Environmental Health Division
1675 W. Garden of the Gods Road
Suite 2044
Colorado Springs, CO 80907
(719) 578-3199 *phone*
(719) 578-3188 *fax*
www.elpasocountyhealth.org

Fox Run Nature Center SDP, PPR-23-49

Please accept the following comments from El Paso County Public Health regarding the project referenced above:

EL PASO COUNTY PARKS  
 EL PASO COUNTY  
 FOX RUN NATURE CENTER  
 UTILITY SERVICES PLAN

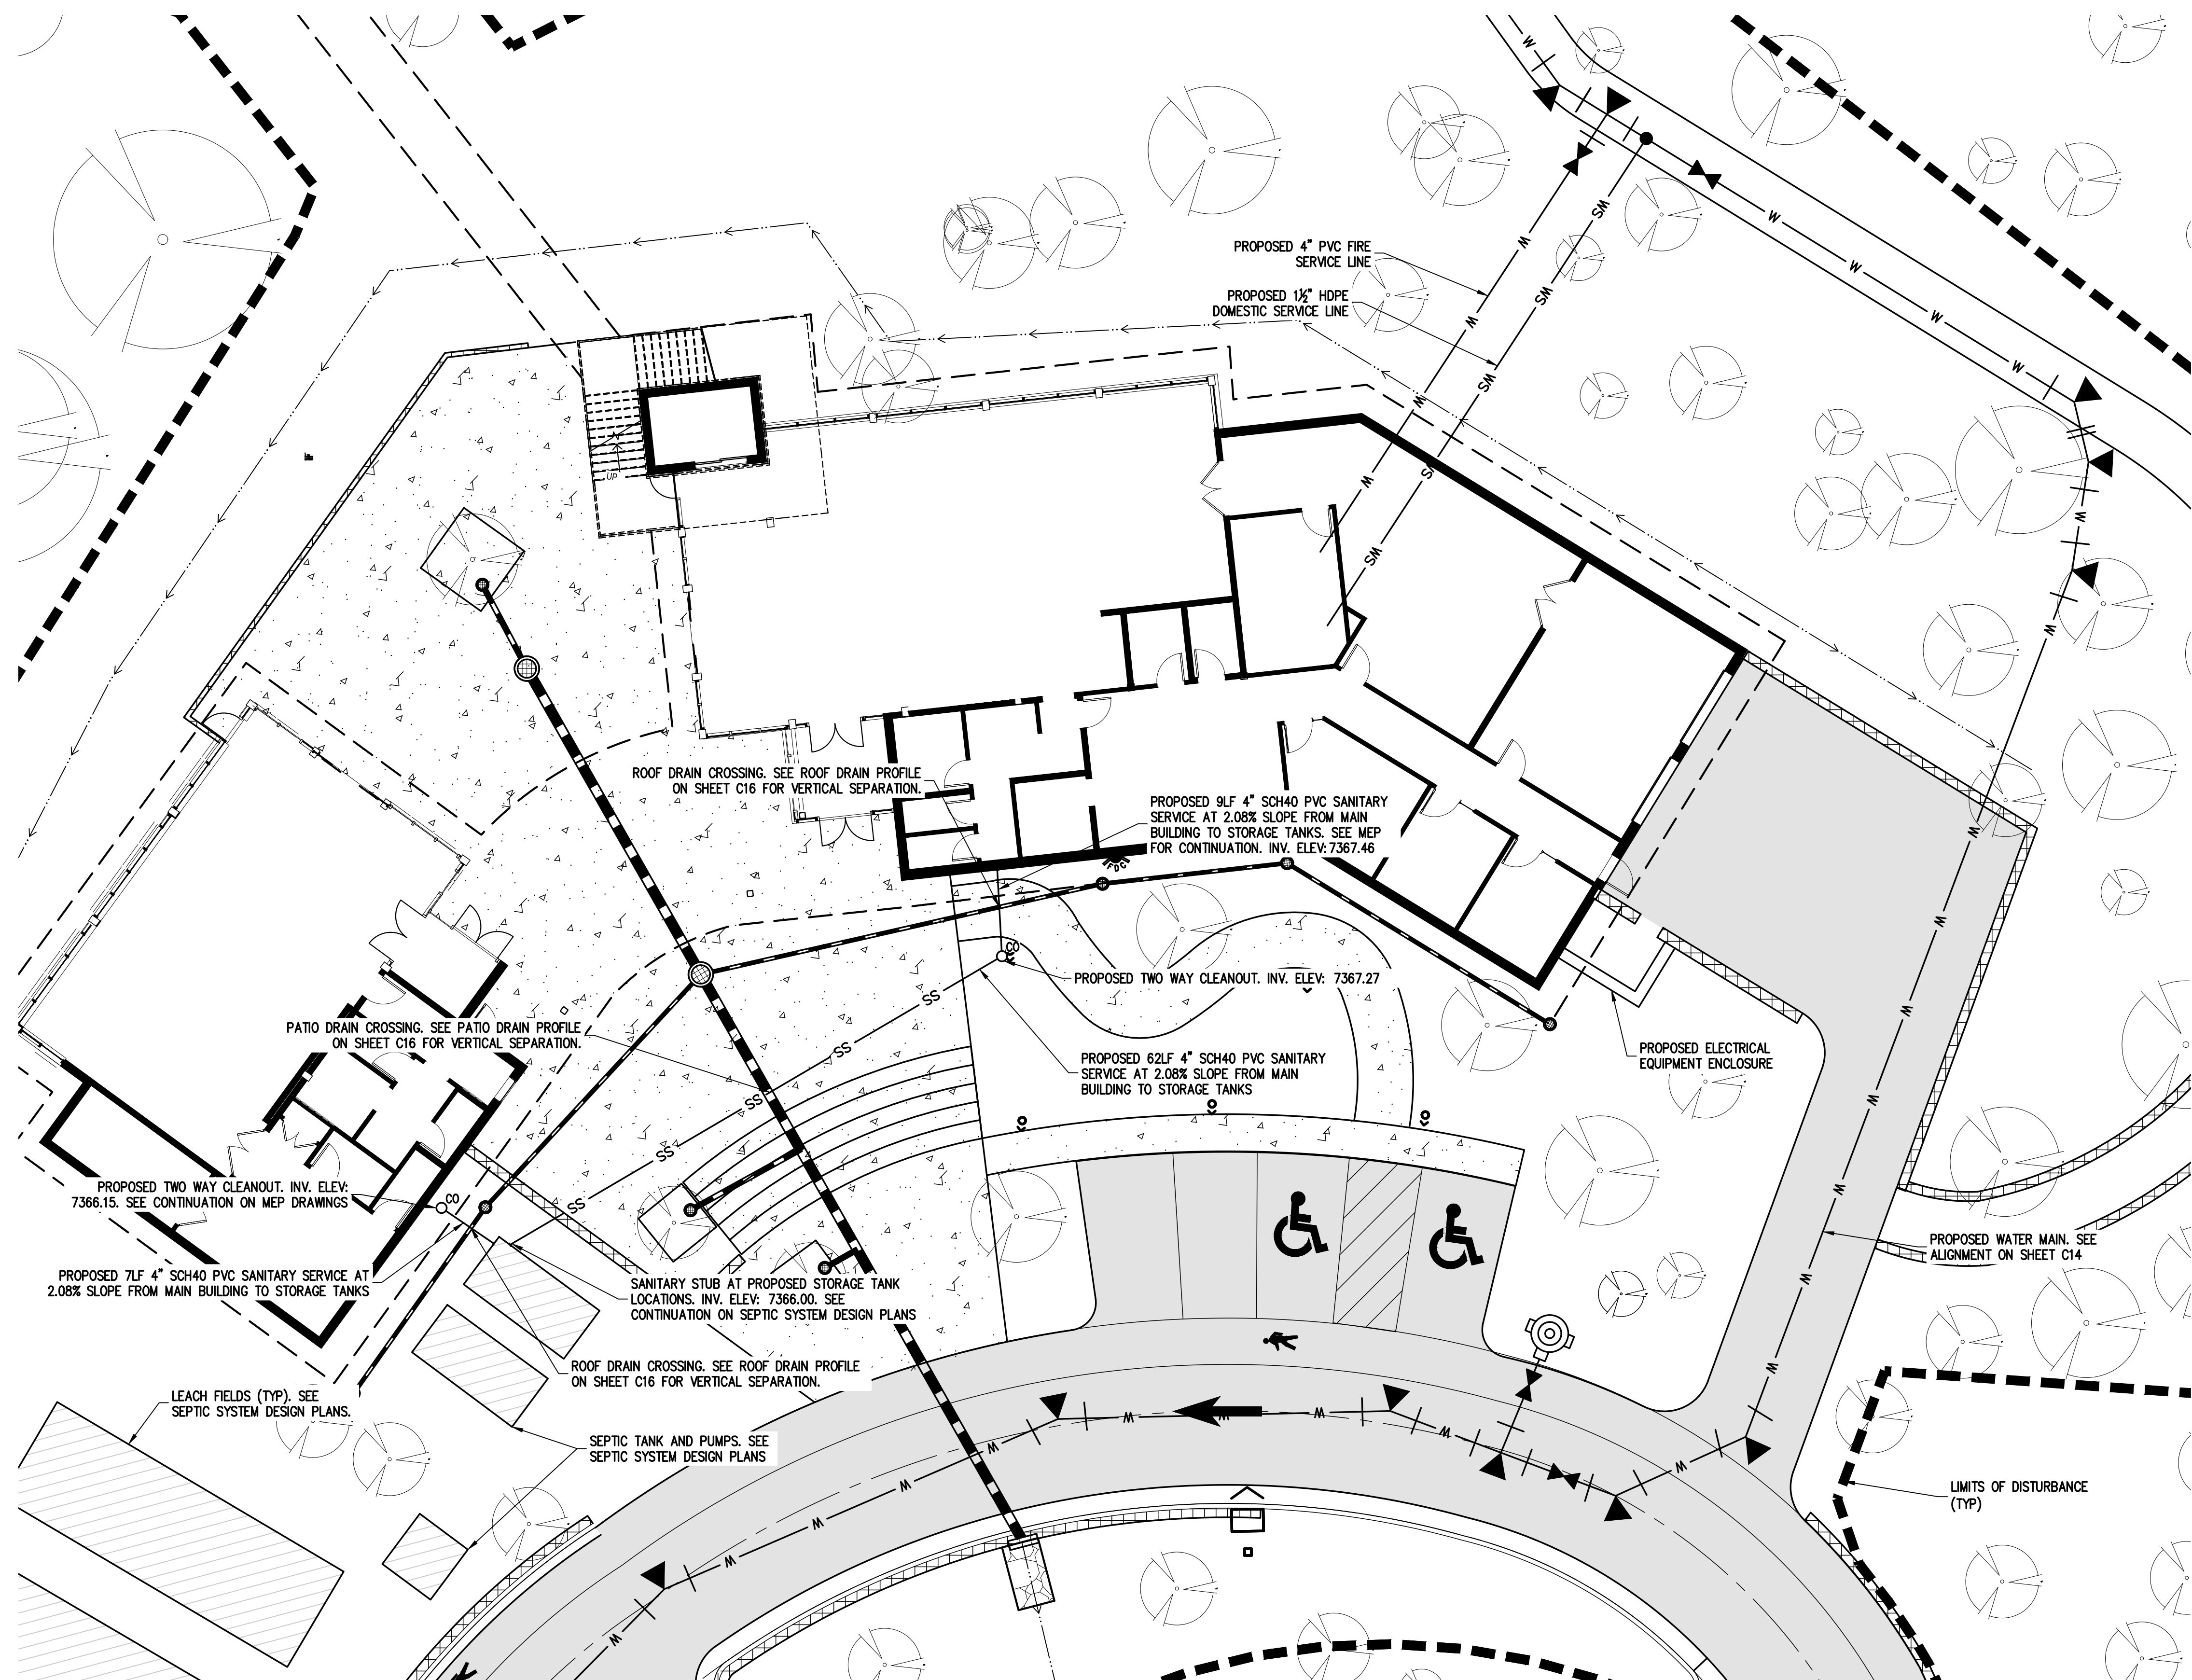
- **Wastewater service was not addressed with this project but appears to be by an onsite wastewater treatment system (OWTS). The OWTS must be sized and designed by a Colorado Registered Professional Engineer and approved by El Paso County Public Health or the Colorado Department of Public Health and Environment, Water Quality Control Division depending on the wastewater flow and strength.**

EL PASO COUNTY  
 FOX RUN NATURE CENTER  
 OVERALL STORM SYSTEM PLAN

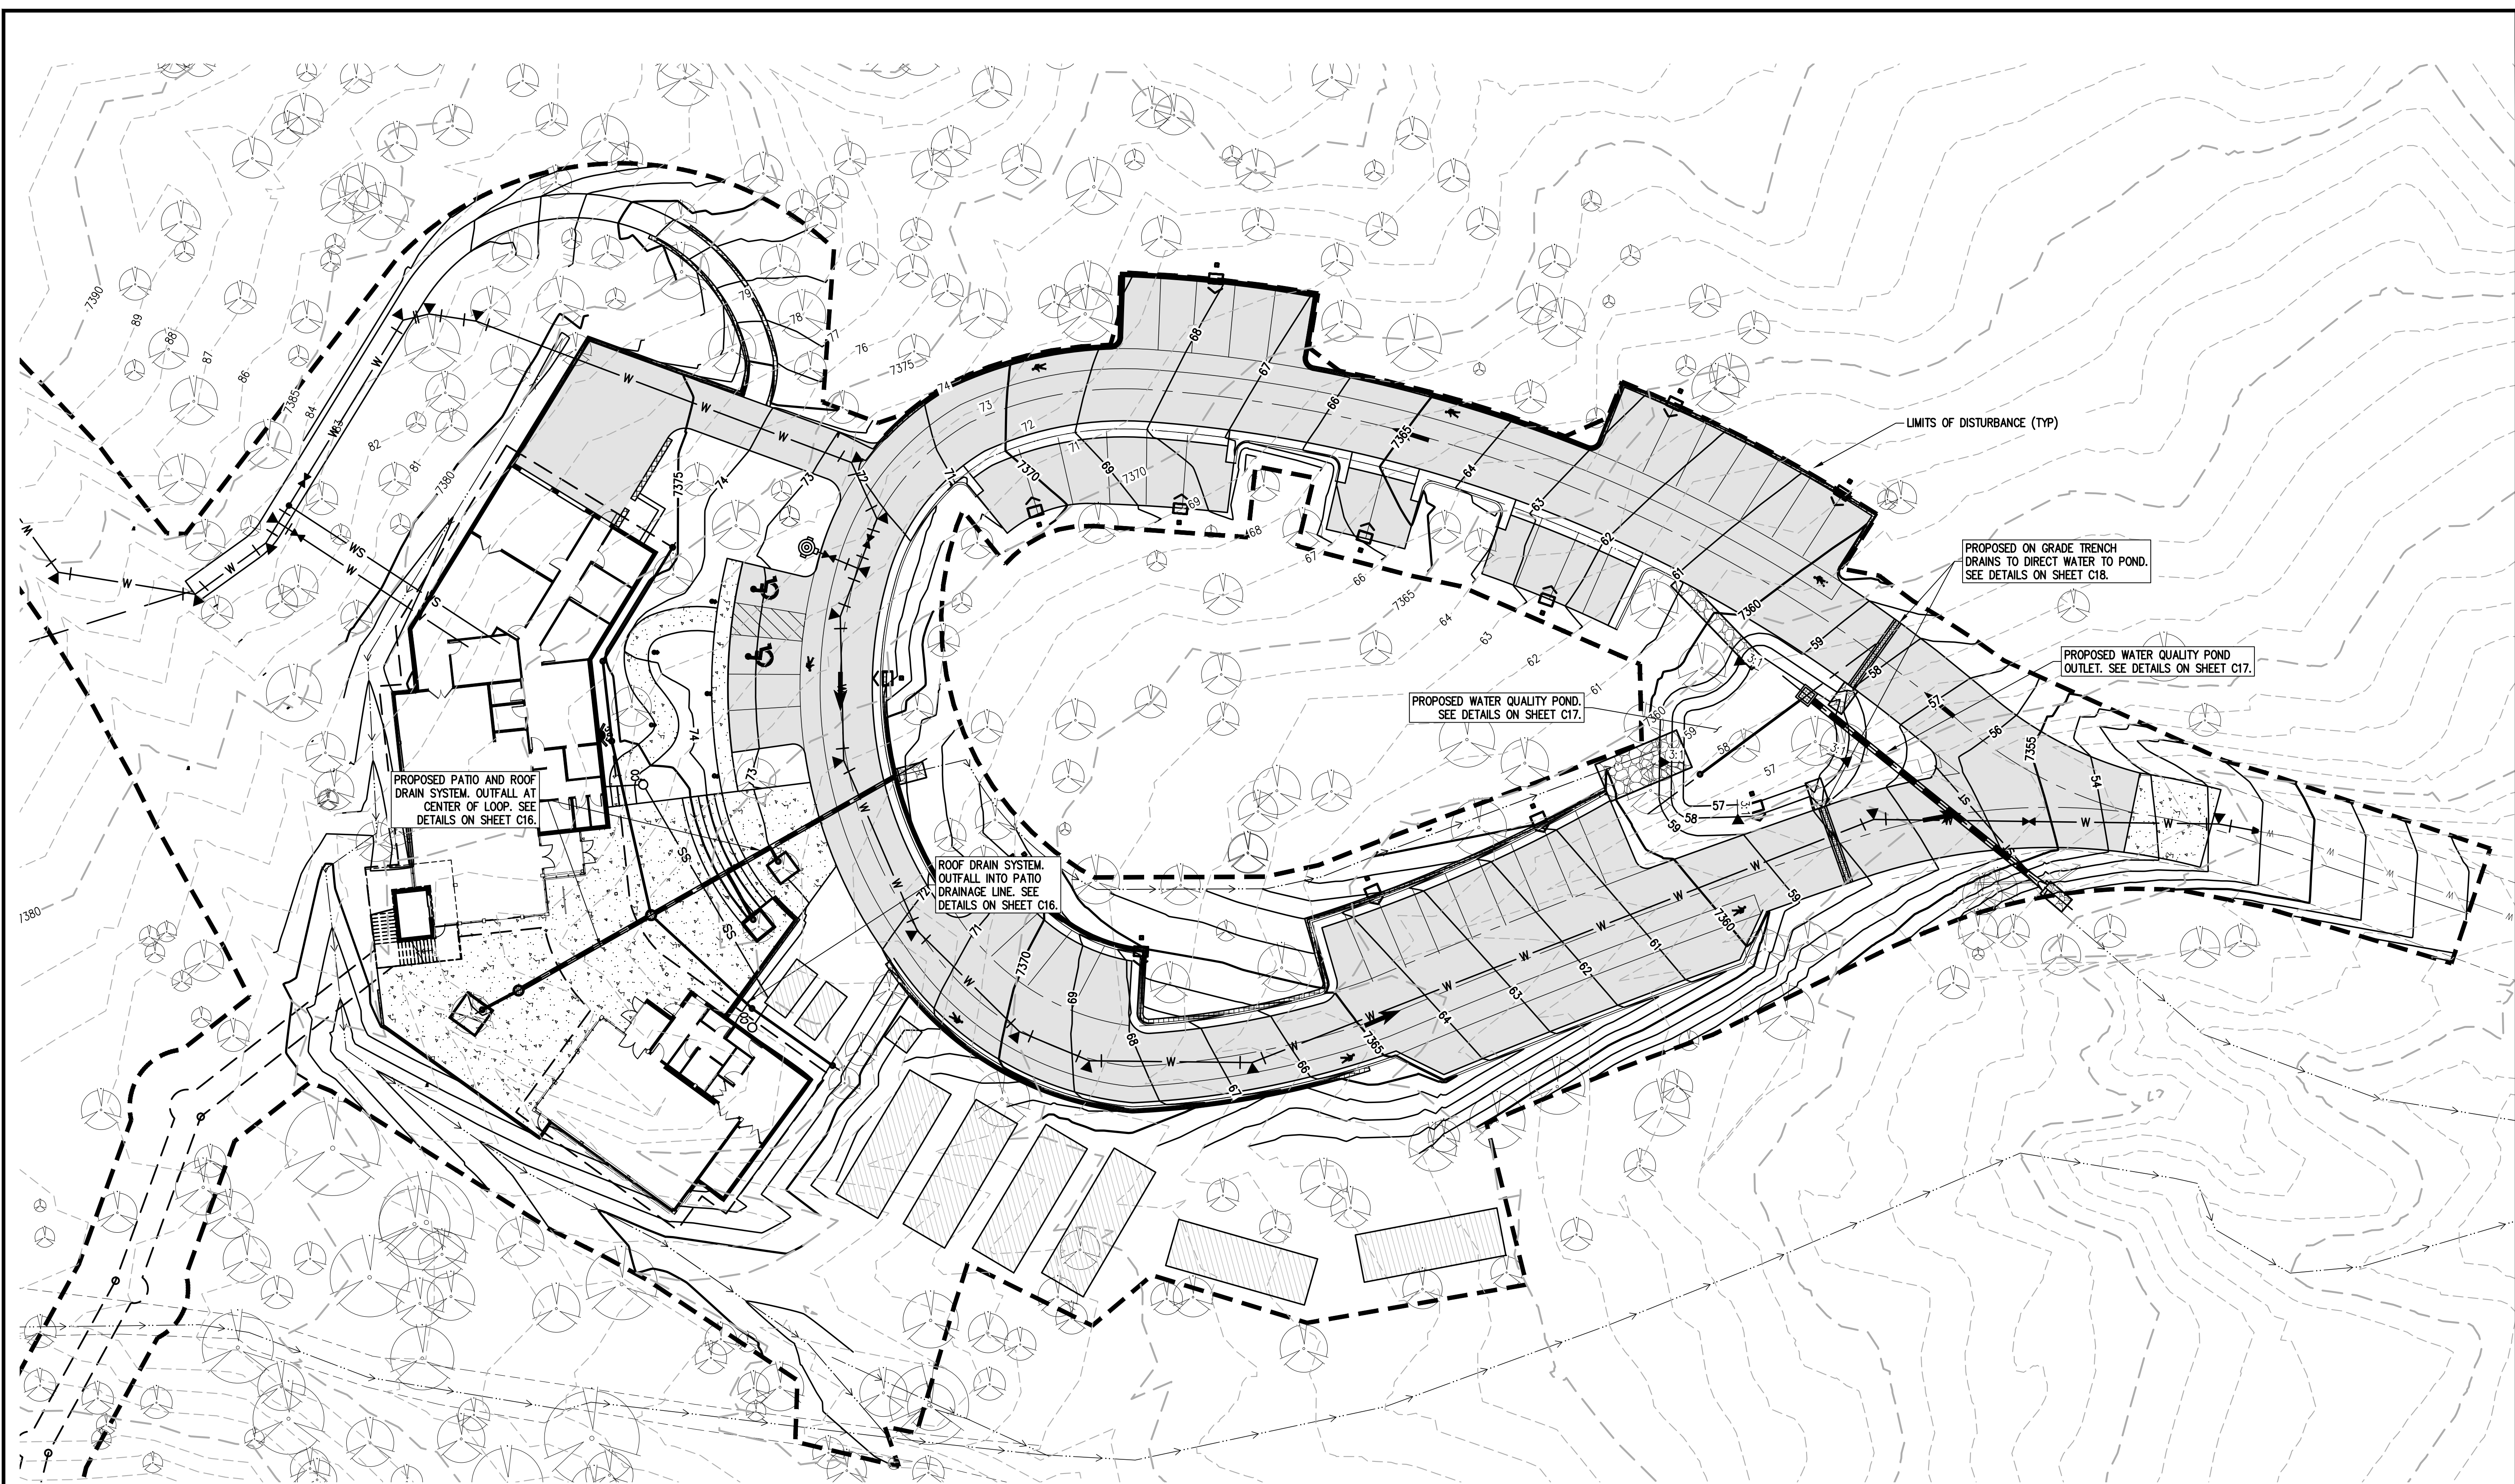
- **The water quality basins must have mosquito control responsibilities included as a part of the construction design and maintenance plan to help control mosquito breeding habitat and minimize the potential for West Nile Virus.**
